Detailed comments:

Officer's Title: Flood Risk Engineer

Date: 27 February 2020

Drawing Title: ACCESS TO COMPOUND A1 GENERAL ARRANGEMENT

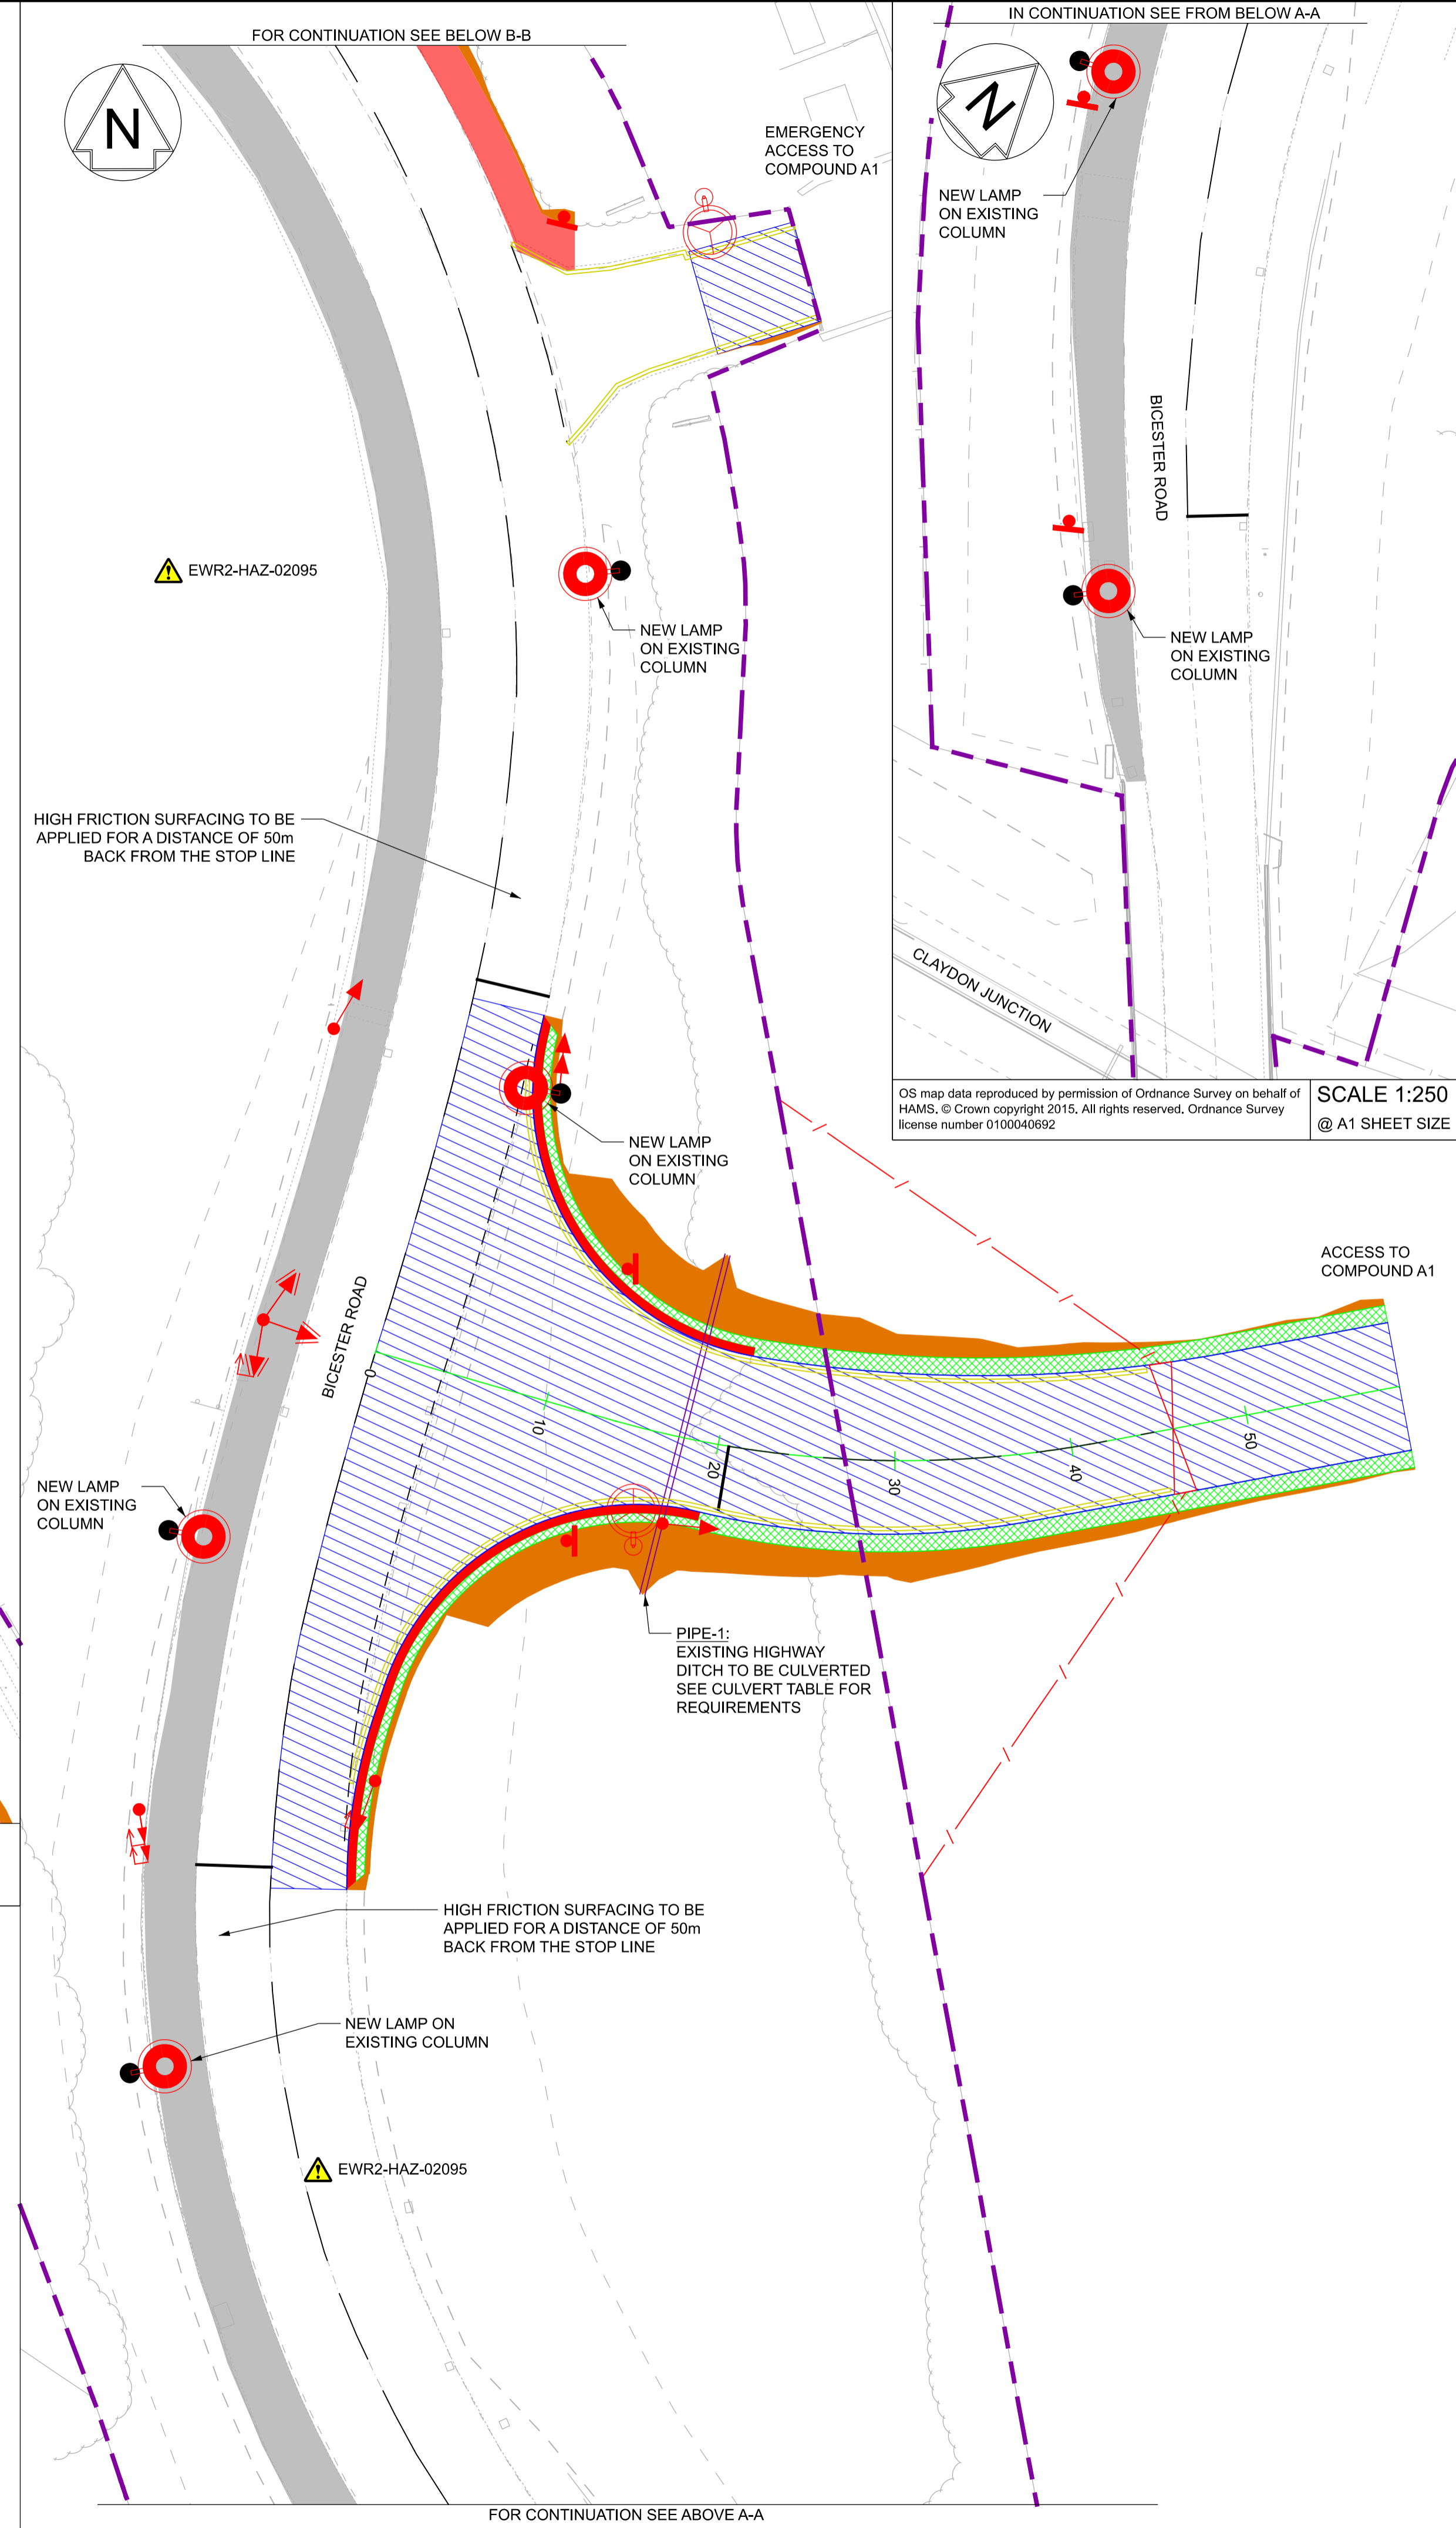
A 300mm culvert is proposed in the ditch under the highway but no information has been provided to confirm the size is acceptable to take the existing flows. We will expect the pipe to be adequate to take the 1 in 100 year + 25% for climate change allowance, in line with EA guidance.
